KITTITAS COUNTY COMMUNITY DEVELOPMENT SERVICES

Subject: Shoreline Exemption Permit
Camping on the River (SX-18-00022)

The Shoreline Exemption Permit application submitted on September 12, 2018 has been deemed **incomplete**. The information provided with your application does not clearly show necessary details of your proposed project. Please provide the following:

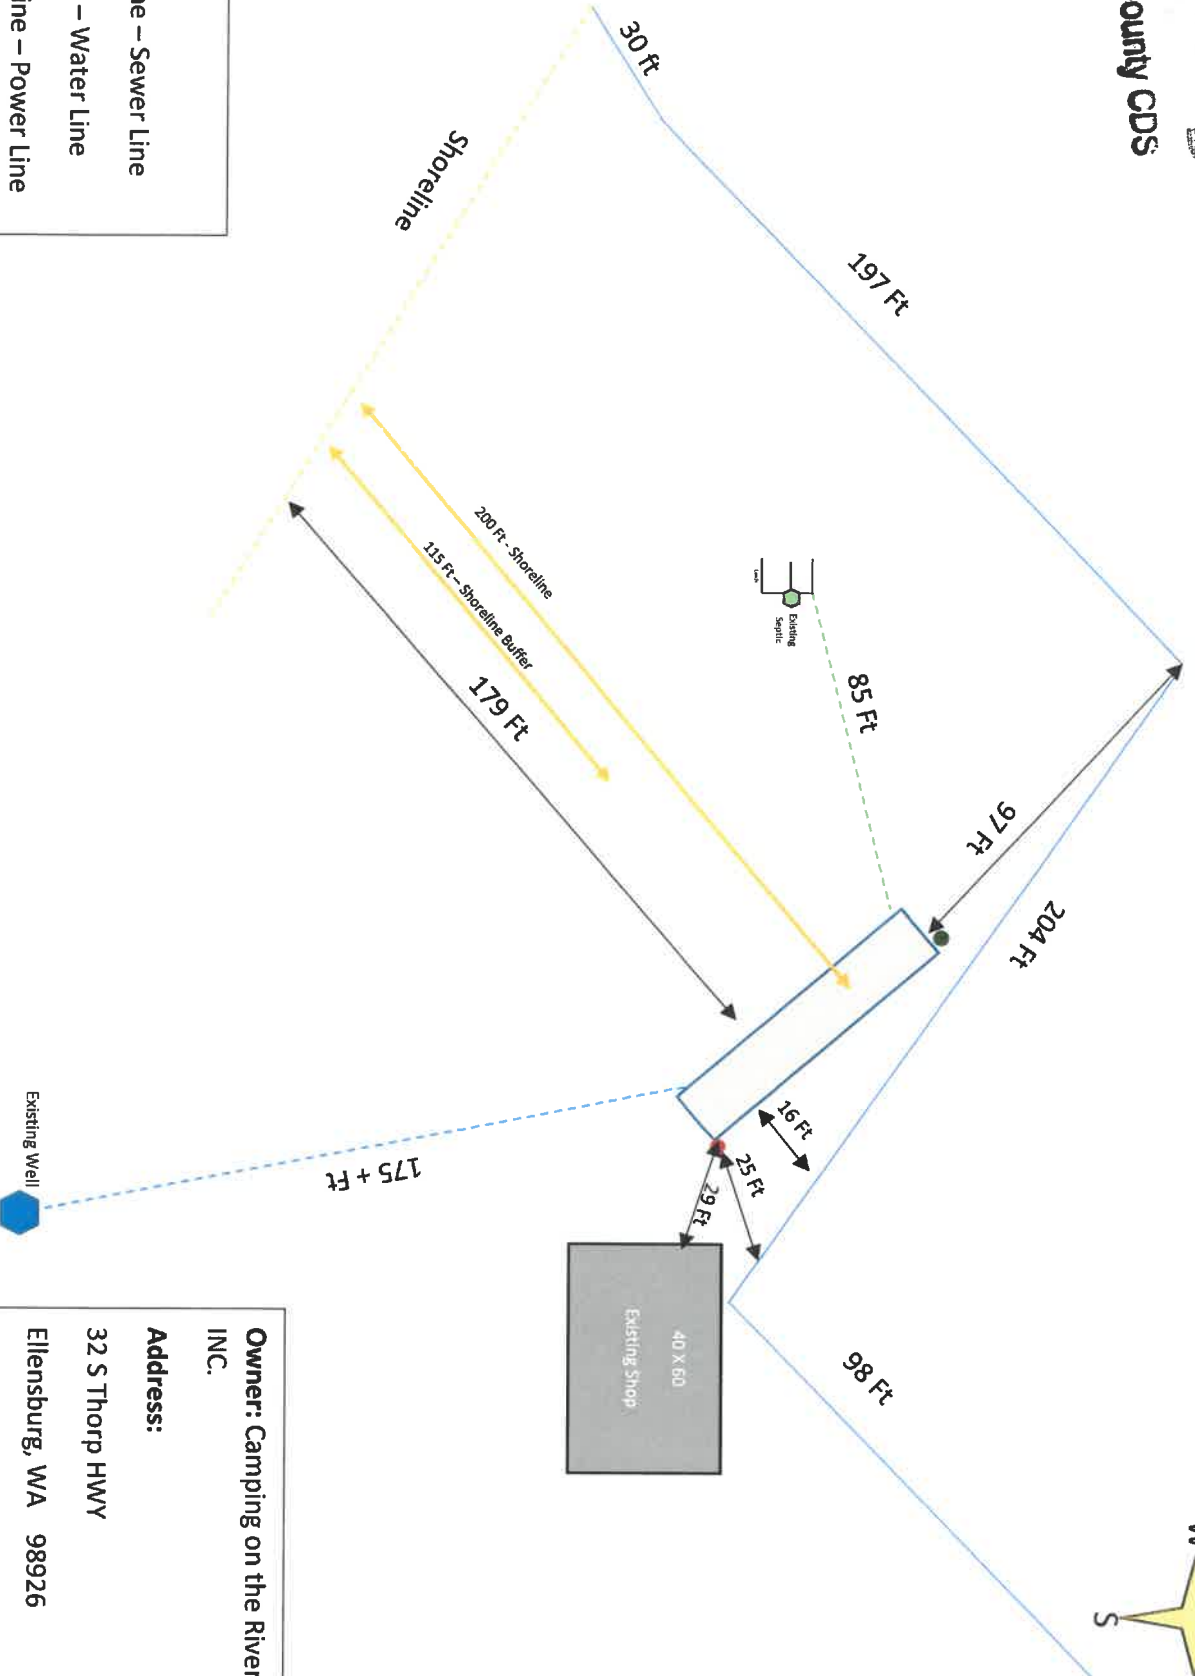
1. Updated Site Plan; your site plan will need to be scaled, show all structures, driveway, setback distances, waterbodies, and any other nearby items (i.e. campsites).
2. Documentation from public works verifying that your project site lies out of the floodway.
3. Documentation showing that your project site is located fully on the identified parcel.
